Marist Catholic College North Shore (SSD-10473)
Response to Submissions

ATTACHMENT 1

Title
GA PLAN - BASEMENT ZONE 1

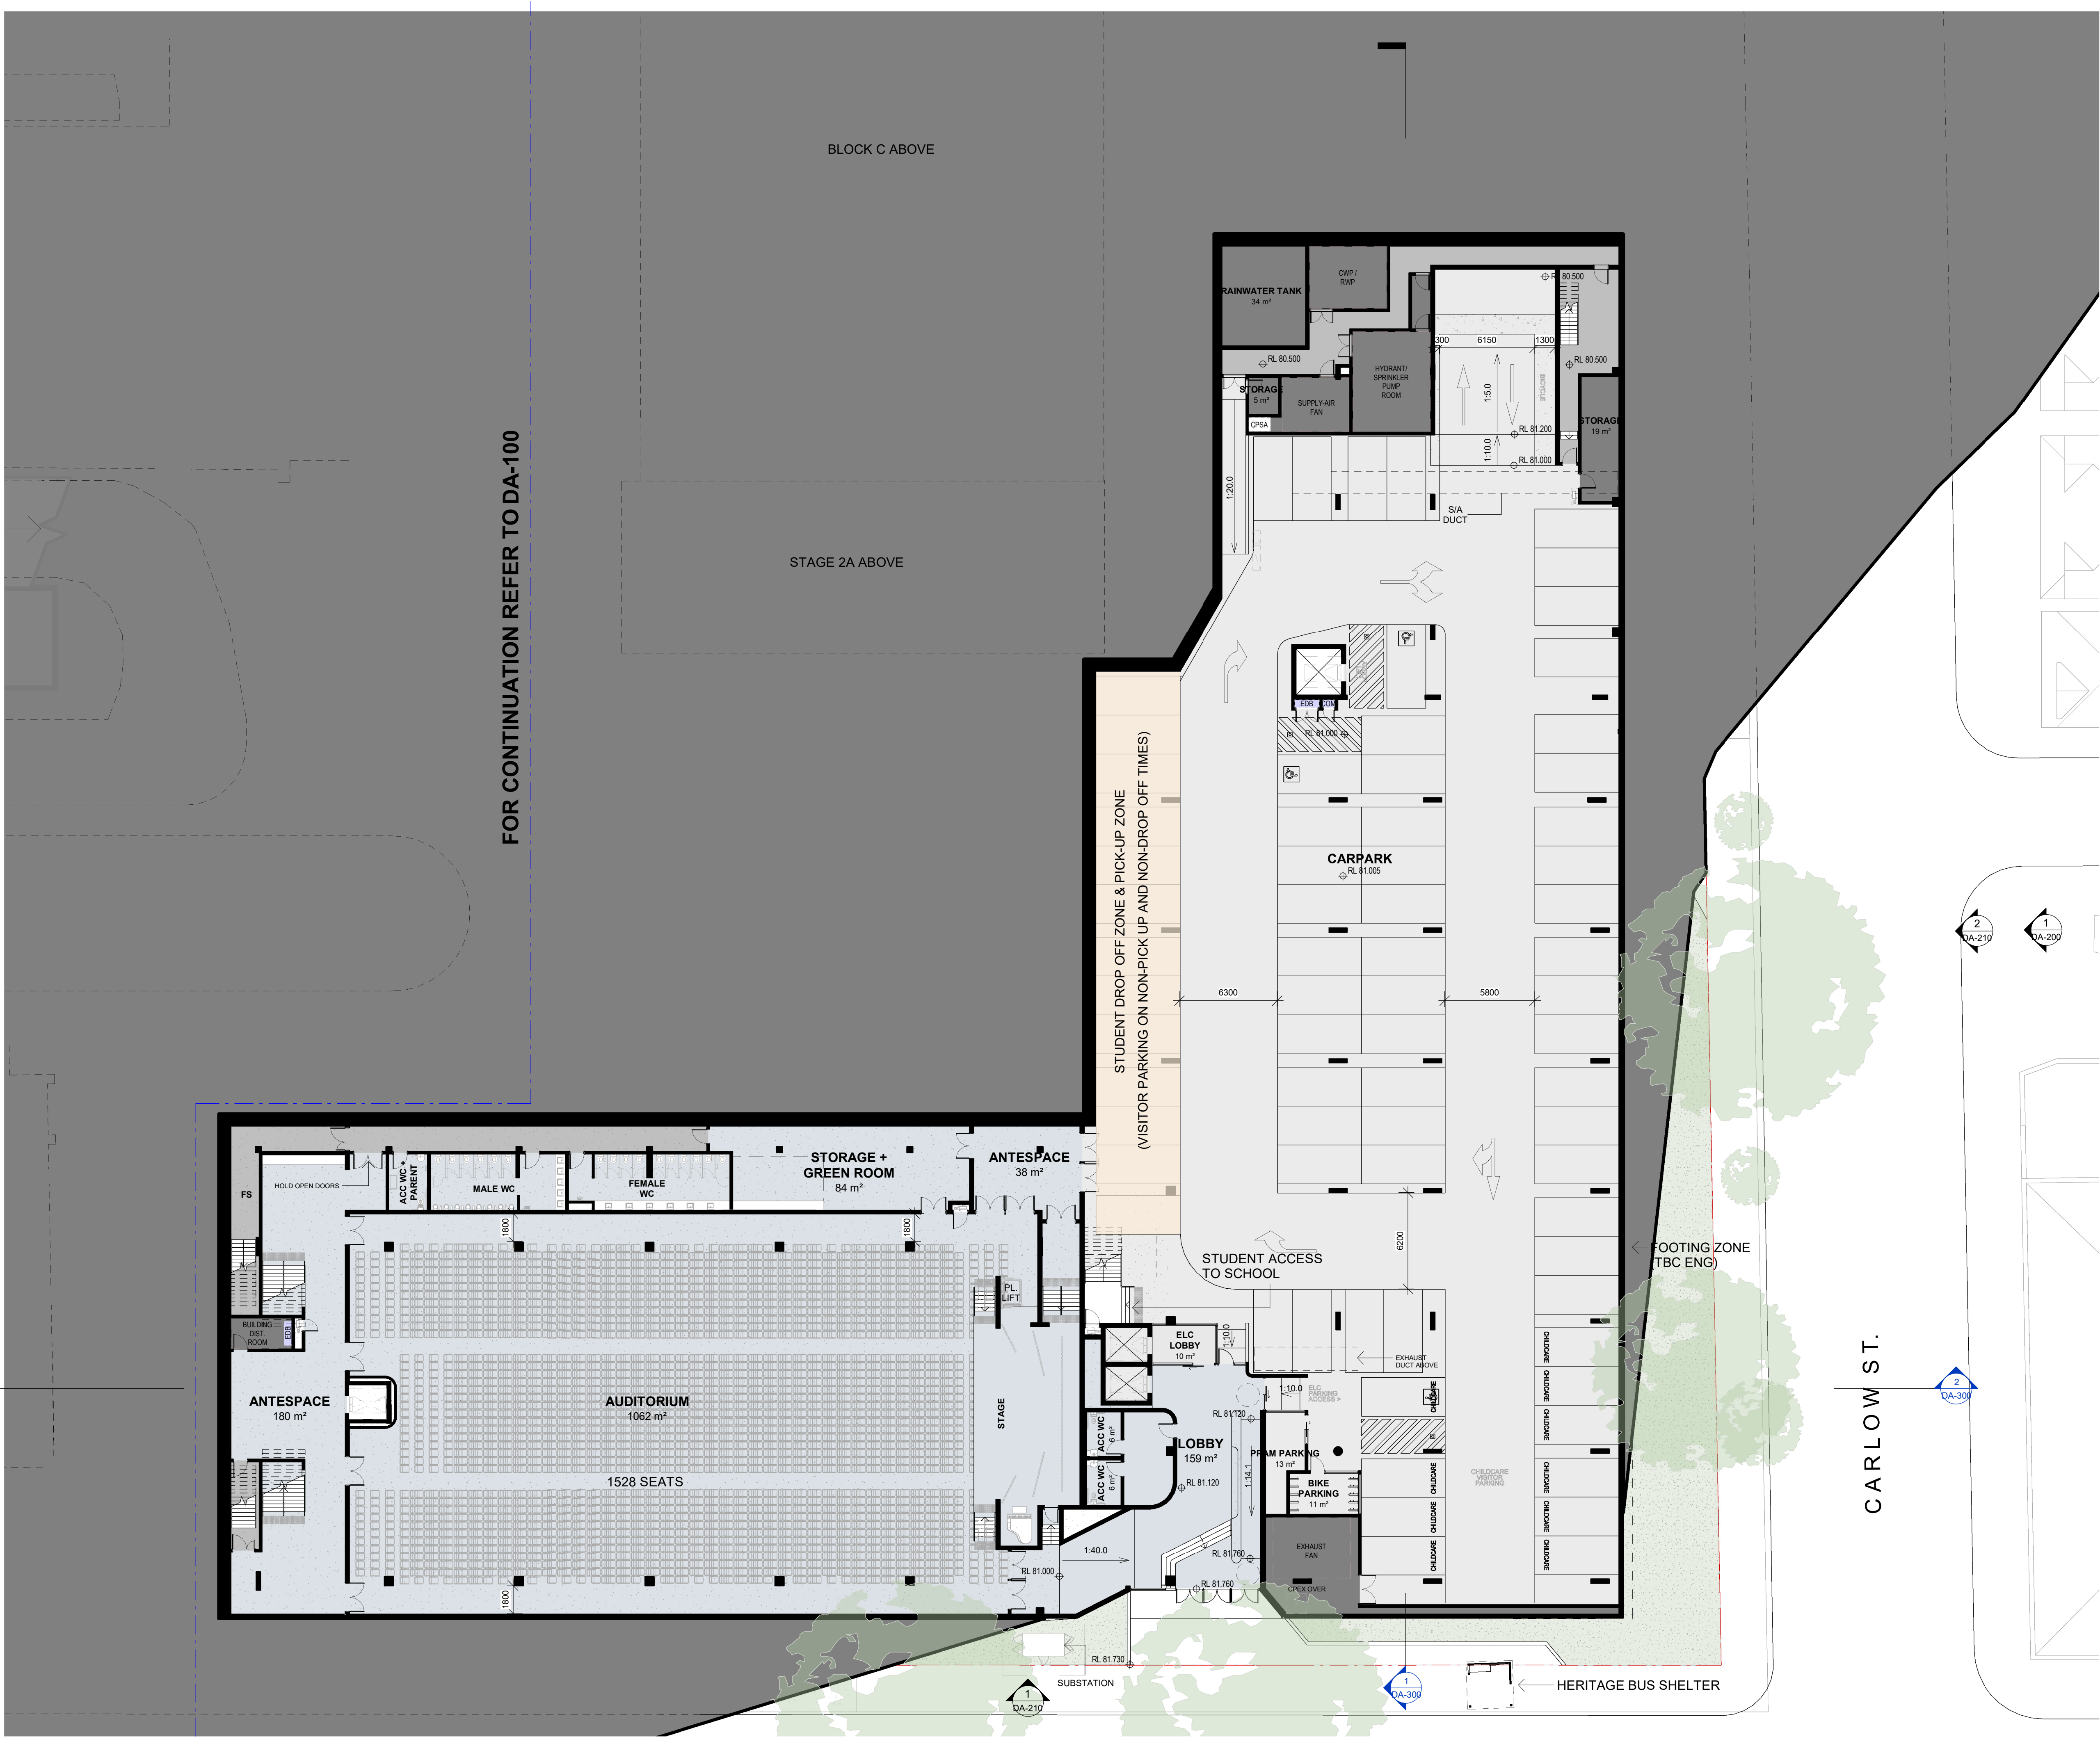
- An excavation plan showing the extent of cut and details of piles for the proposed basement carpark at the Carlow Street Building is required to identify the depth of the basement car park in respect to the Sydney Metro Railway easement that runs directly beneath the site.
- The plan must show the details of the Sydney Metro tunnel depth at this location which should be obtained in consultation with the public authority.
- The Architectural plans provided should be updated to highlight the drop off and pick up location that has been allocated to students in the Carlow Street Building basement car park.

Title
STREETSCAPE ELEVATIONS

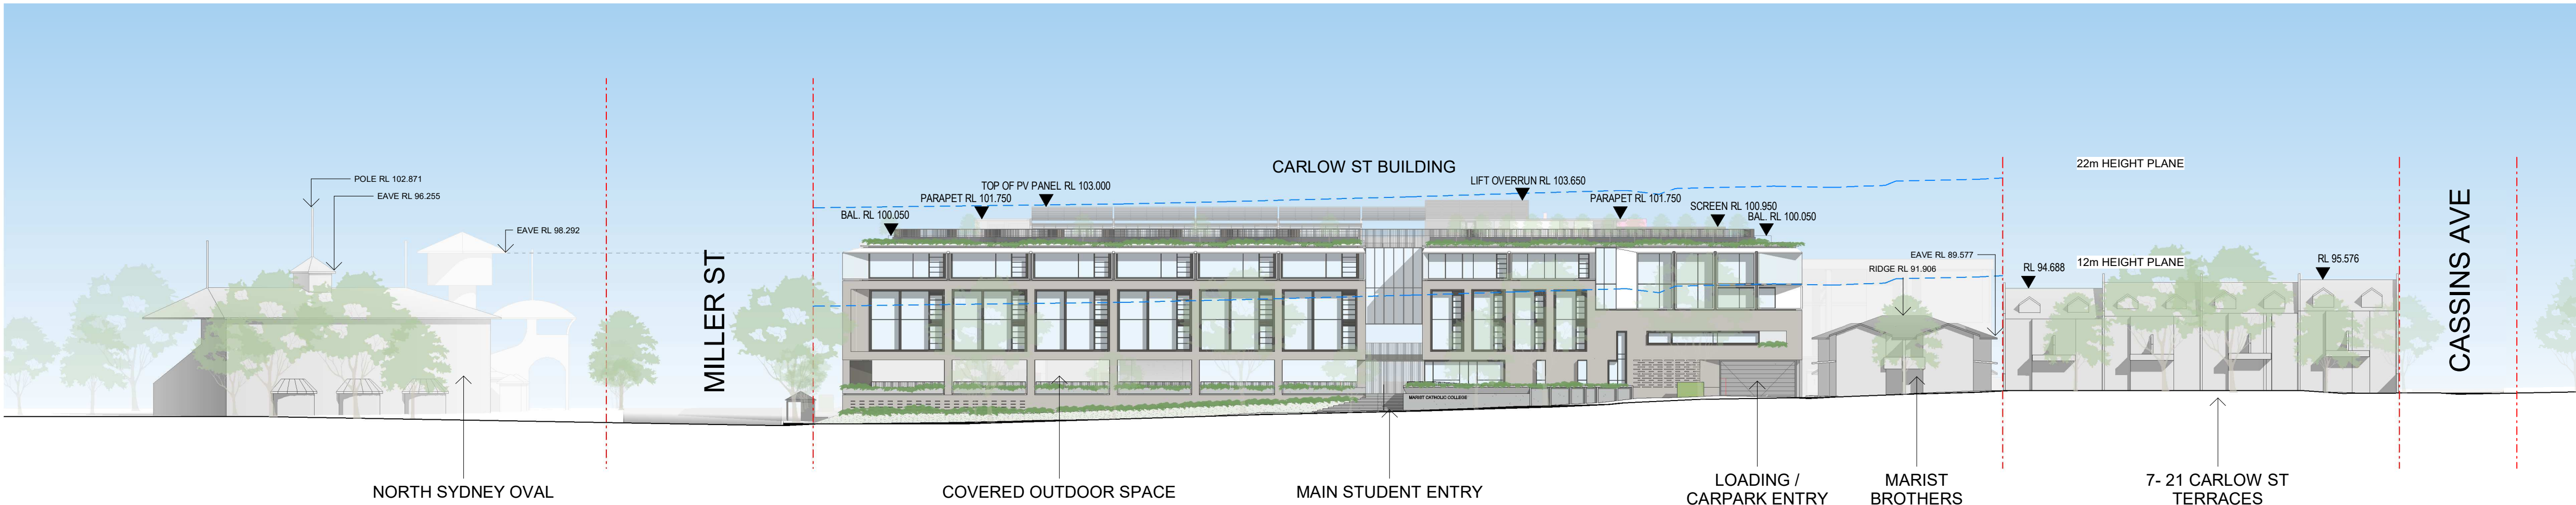
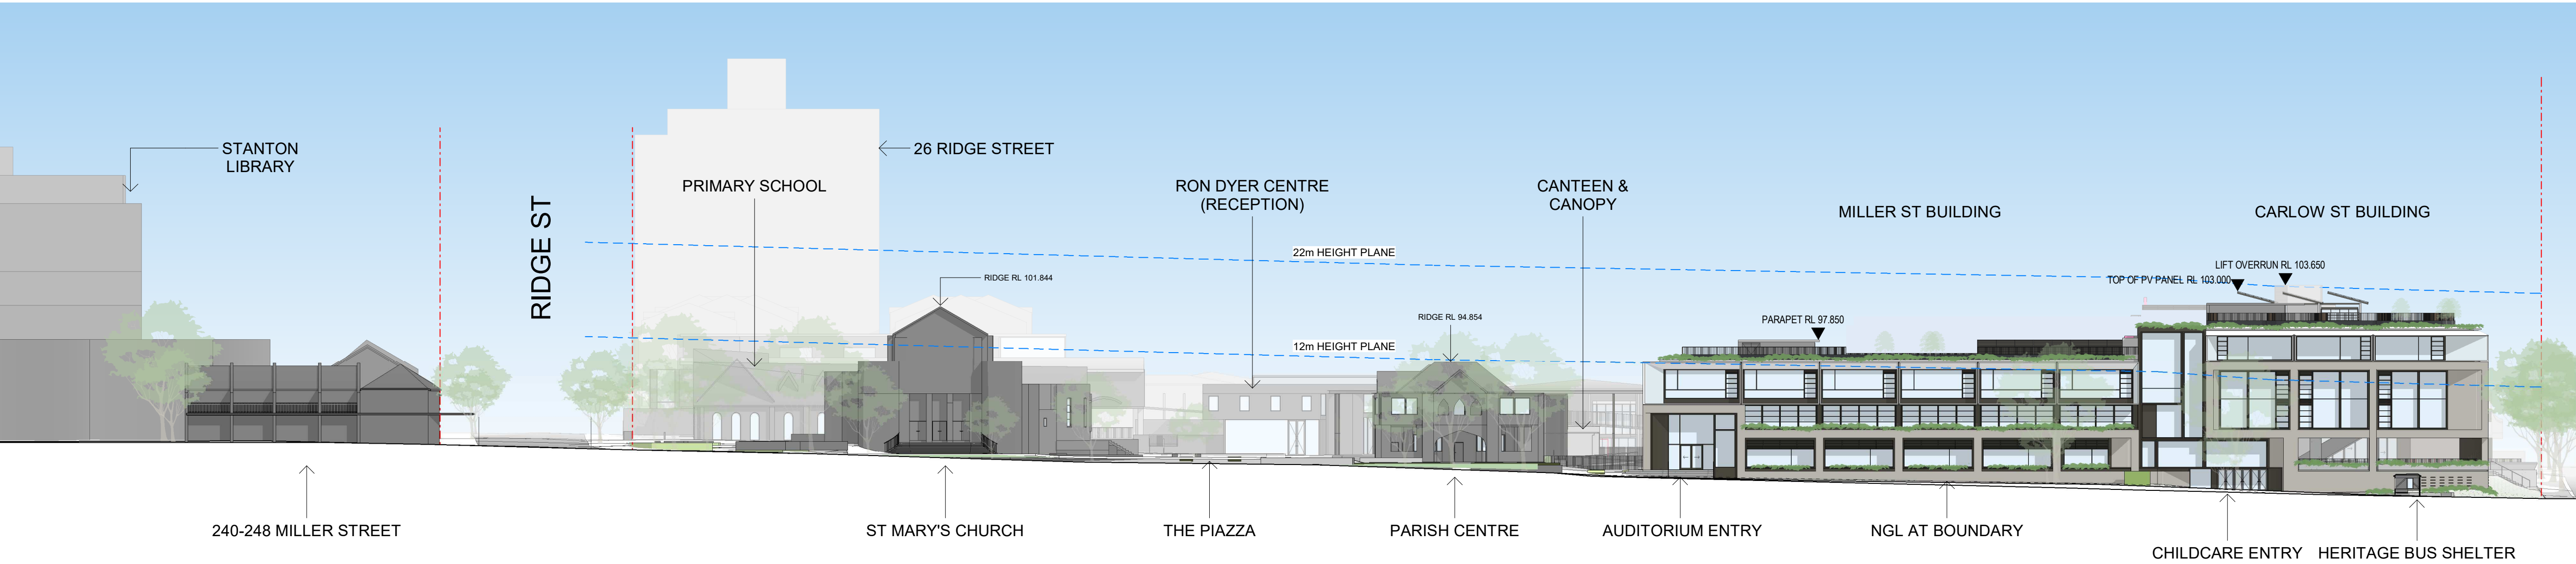
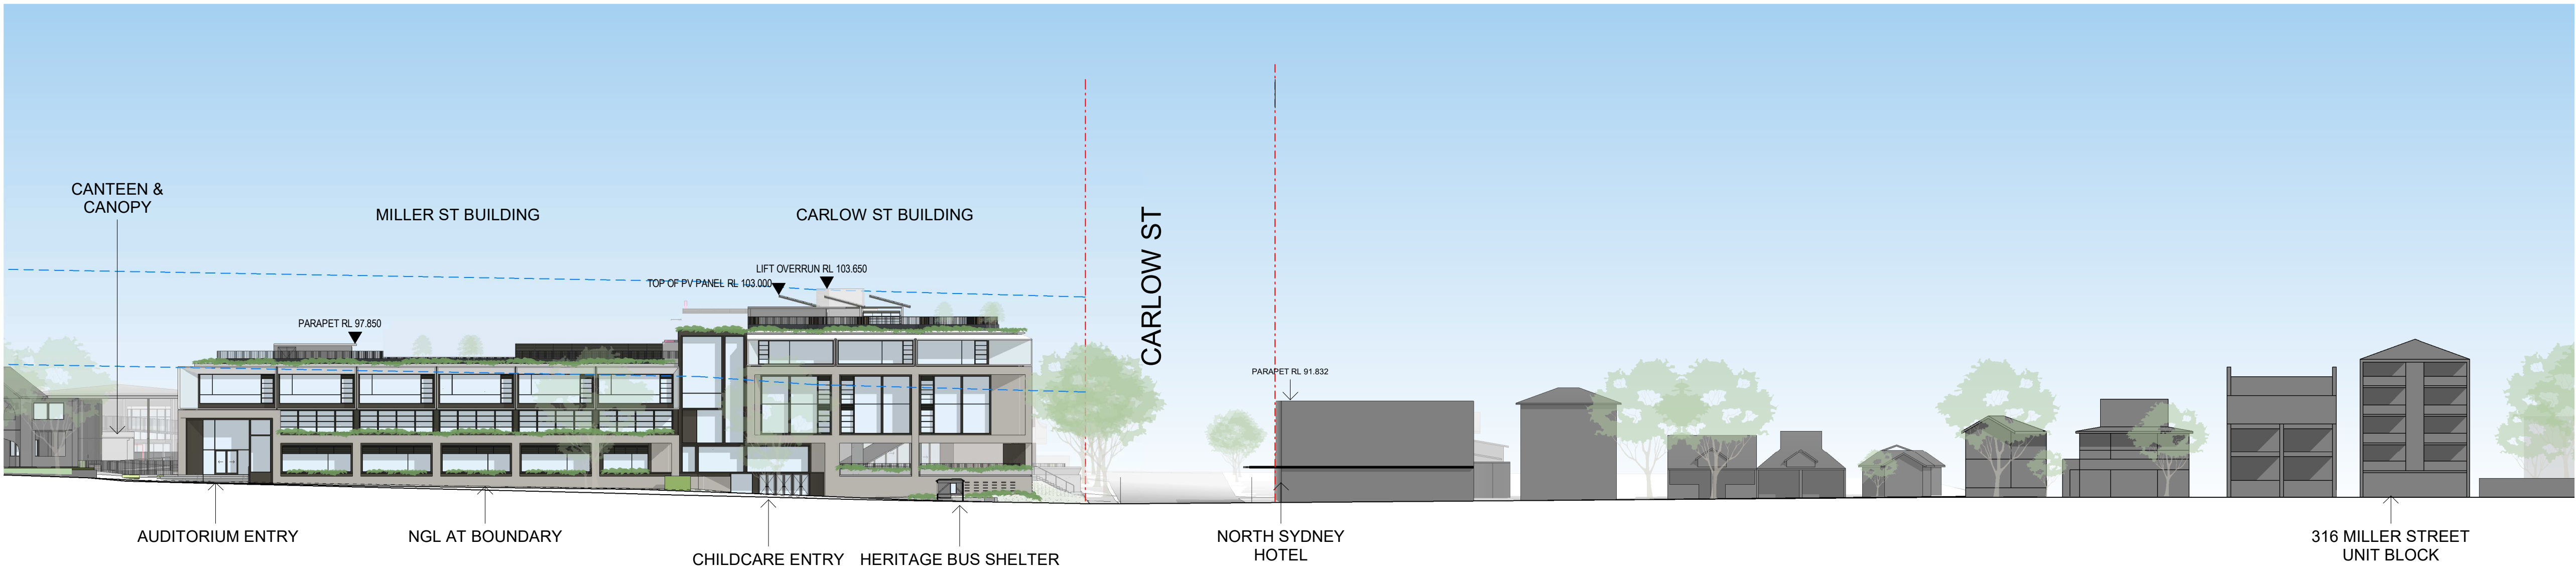
- The Visual Impact Assessment (VIA) report is to be updated to consider the visual impacts that would eventuate from the proposed setbacks and the bulk and scale of the proposed buildings on the site’s surrounding heritage items.
- Further consideration should be given to the potential to provide natural screening for the site in order to reduce the bulk and scale of the proposed building. This may require consideration of street tree planting, if there is not sufficient space within the site.
- Consideration to further articulate the façade on Miller Street and stepping the building down following the slope of the land should also be considered.
